On behalf of Huddersfield Civic Society.

Huddersfield civic society wish to object to the particular detail in this latest application to install a false ceiling on the ground floor level intended to cover/obscure a grand possibly Victorian moulded ceiling.

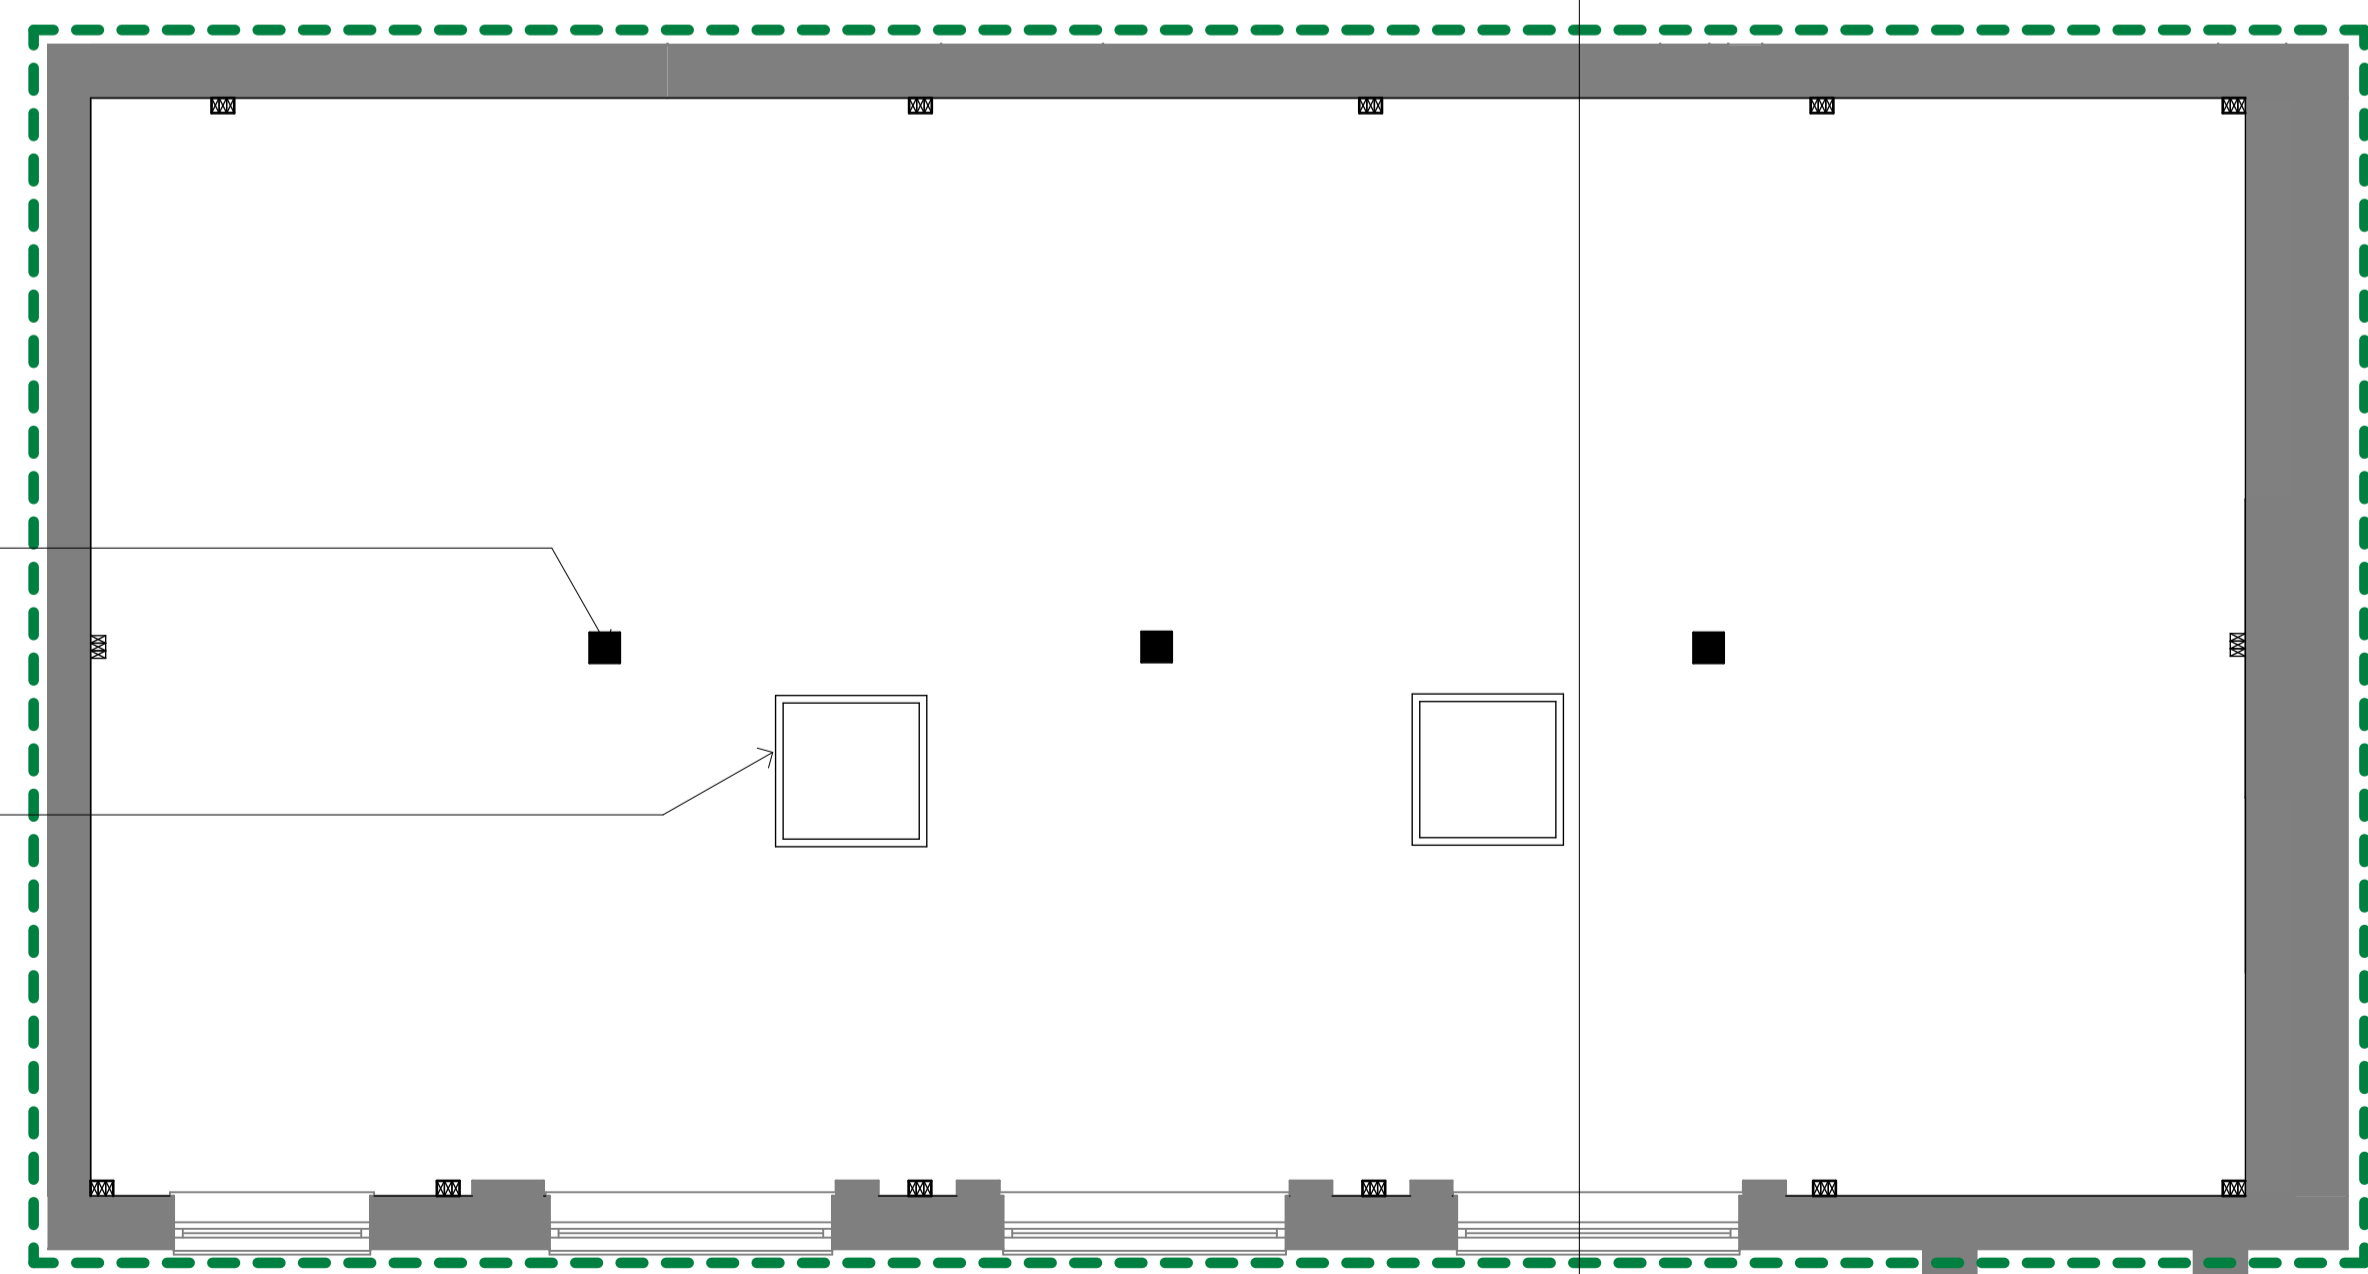
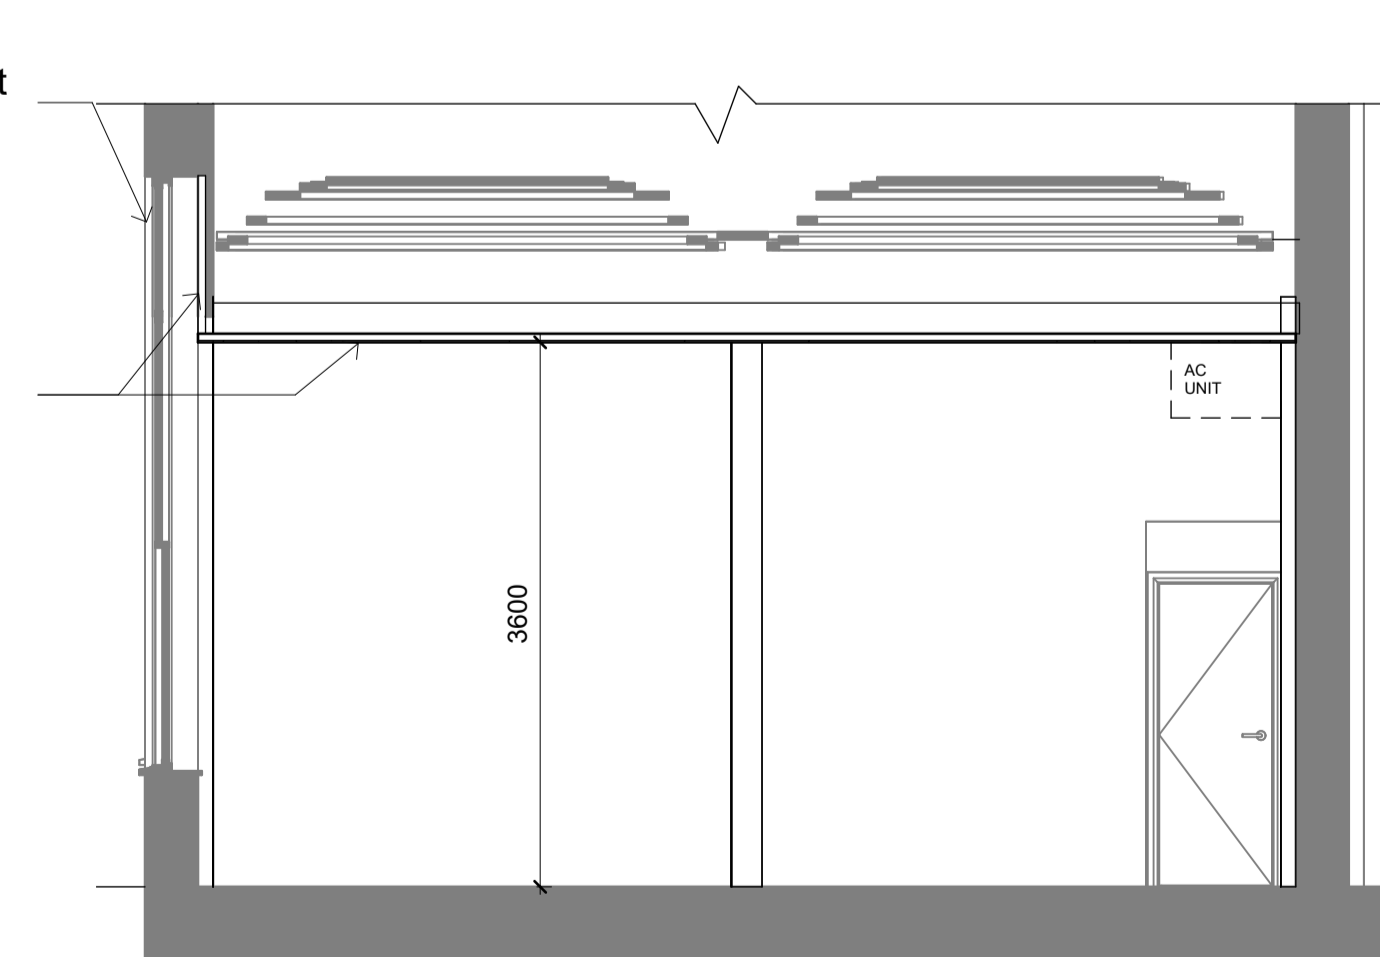
The "planning and heritage statement concedes that the ceiling in question has the following :- "A coffered structure sectioned into eight squares. Six of these divisions feature highly decorative coving in several layers with floral patterns to the recesses. In each coffer there is a central ceiling rose decorated in blue. Where the divisional lines of each coffer converge there is a circular extrusion detail"

It would seem more appropriate to leave this feature visible, and in fact a feature that could be highlighted by the ultimate tenant.

Paragraph 208 of the NPPF sets out that 'local planning authorities should identify and assess the particular significance of any heritage asset that may be affected by a proposal. They should take this into account when considering the impact of a proposal on a heritage asset, to avoid or minimise any conflict between the heritage asset's conservation and any aspect of the proposal'. 27. The Kirklees Local Plan Policy LP35 describing Historic Environment states: "Development proposals affecting a designated heritage asset should preserve or enhance the significance of the asset."
